## Change Order

**Peter & Judy West**  
 18 Pine St  
 Portland, ME 04102

EXPLODED VIEW
DOUBLE-HUNG WINDOW

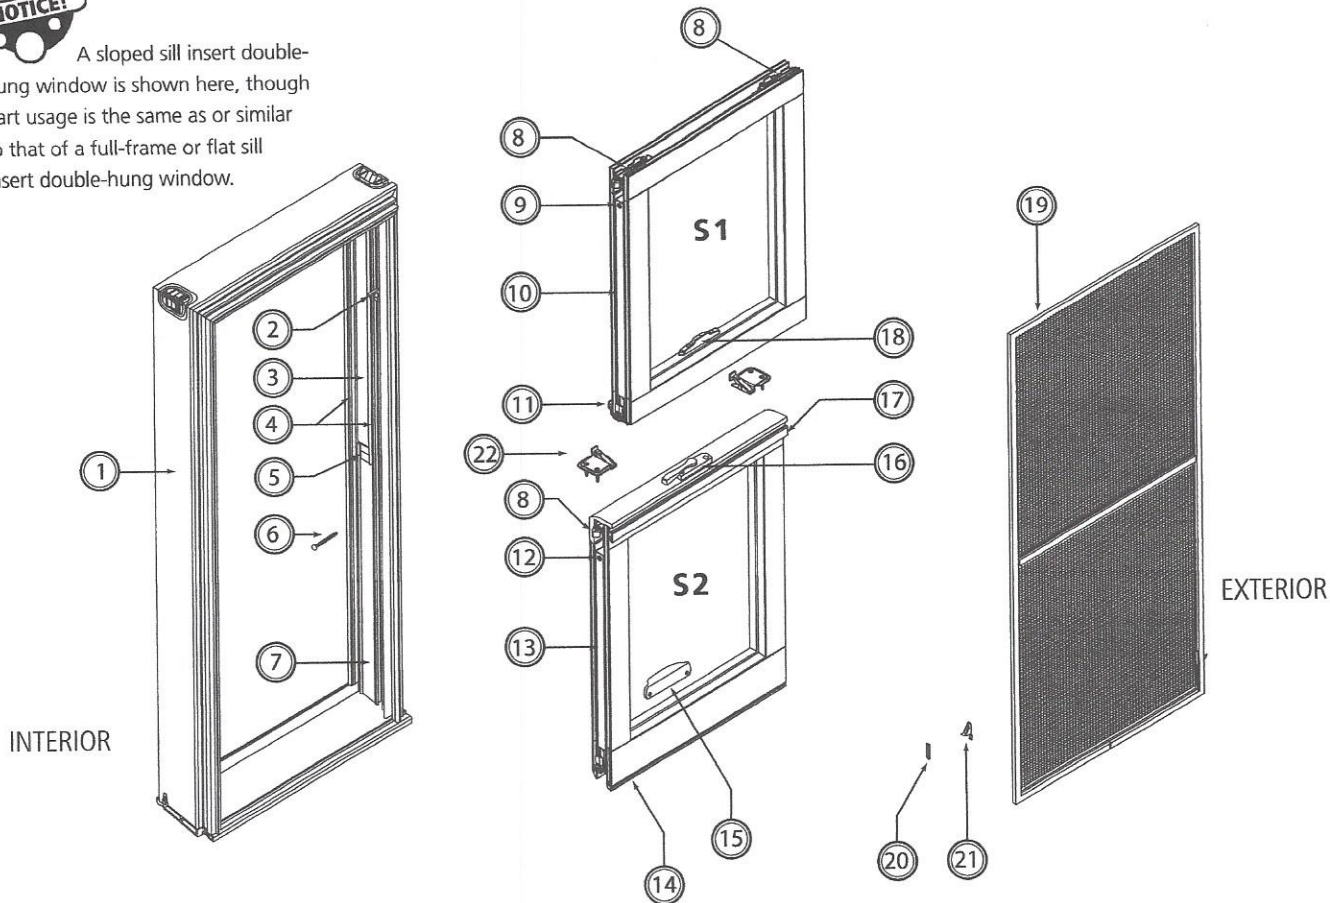
Add Full Divided Lite Grilles (6 over 6) to both sashes on  
 Double Hung Windows #101 and #102 in Living Room
